March 1, 2006

RE: Application for Lot #11, Willow Knoll Subdivision

Upon review of the site plan, the City's Planning Division has the following comments:

GENERAL SITE PLAN

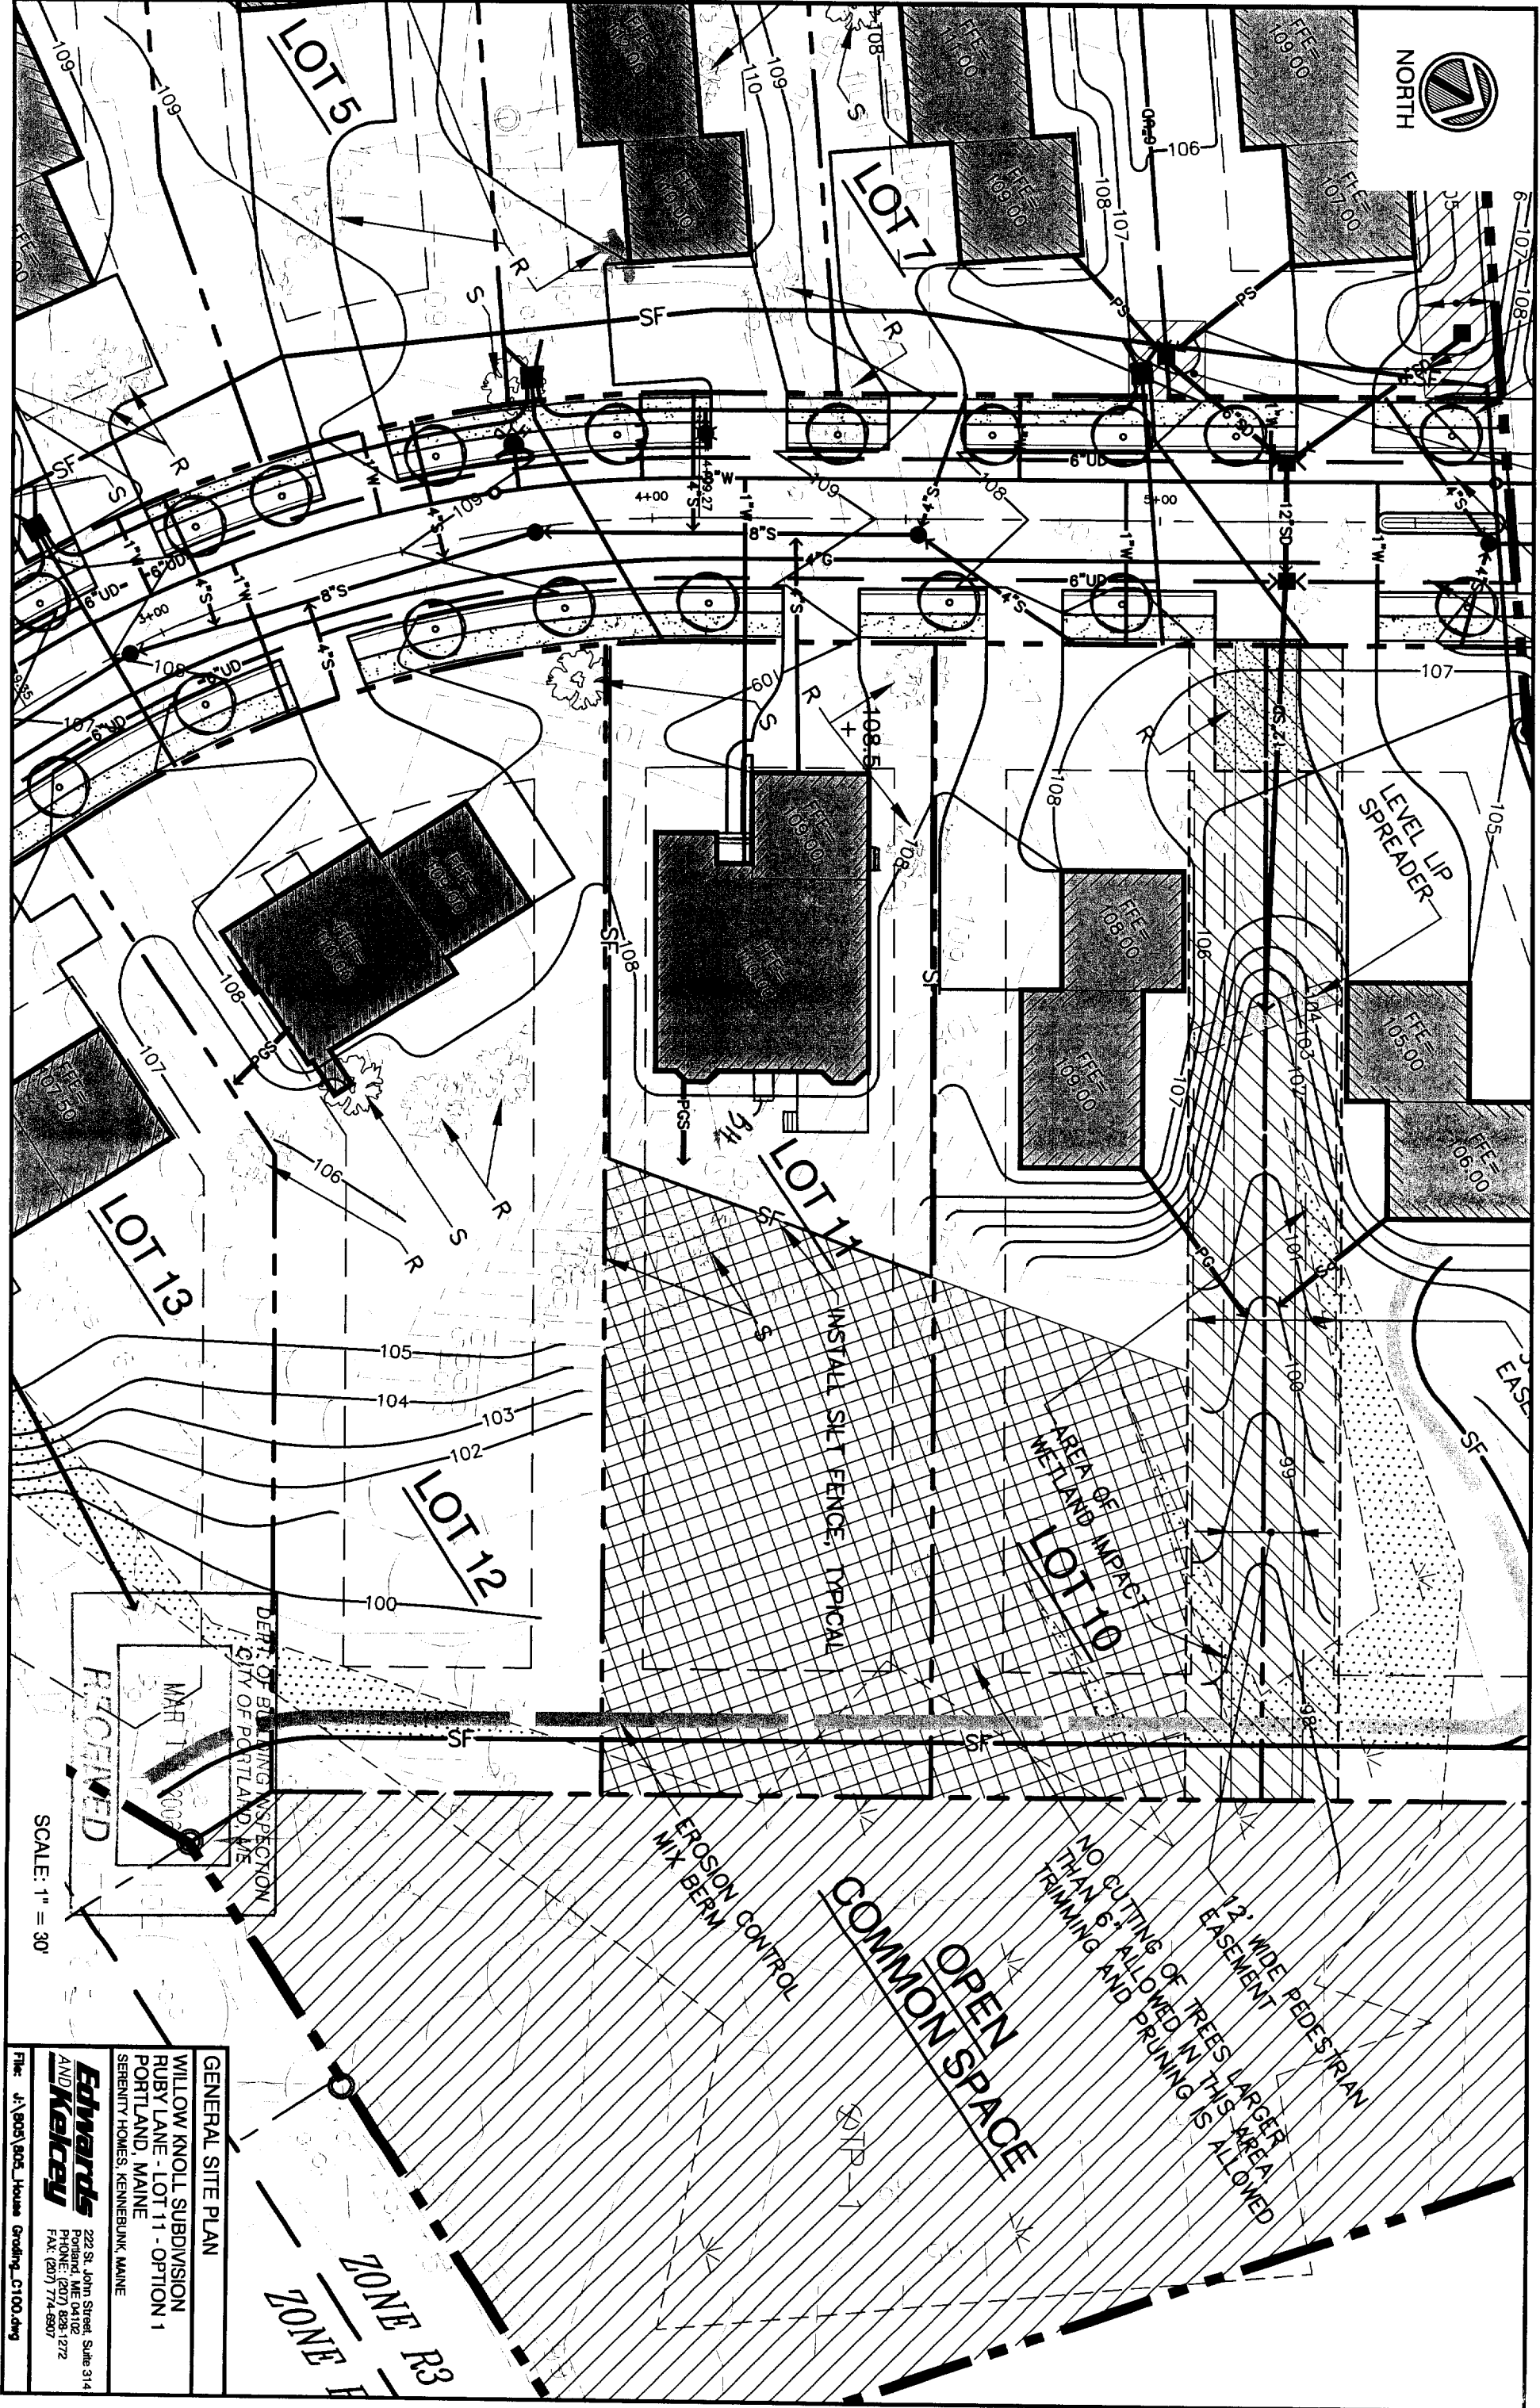
1. The site plan shows significant grading/soil disturbance within the no-cut zone. This grading will not be allowed in this zone due to its impacts on the existing trees. Also, it would not allow for the preservation of the 2 trees identified to be saved (as part of the original subdivision approval).

It also appears that this would involve a 10 to 15-foot cut involving blasting of ledge to achieve this, and would result in a 2:1, or 50% side-slope.

I understand the appeal of the daylight basement; however, this lot does not appear to accommodate this design.

2. Please redirect the storm drain/rain gutter so that it does not discharge onto your neighbor's property.

3. Please reset the silt fence location so that it is out of the no-cut zone.

4. The parking space to the left of the garage will need to be removed, as it does not meet the City's zoning requirements (5' from side property line minimum).
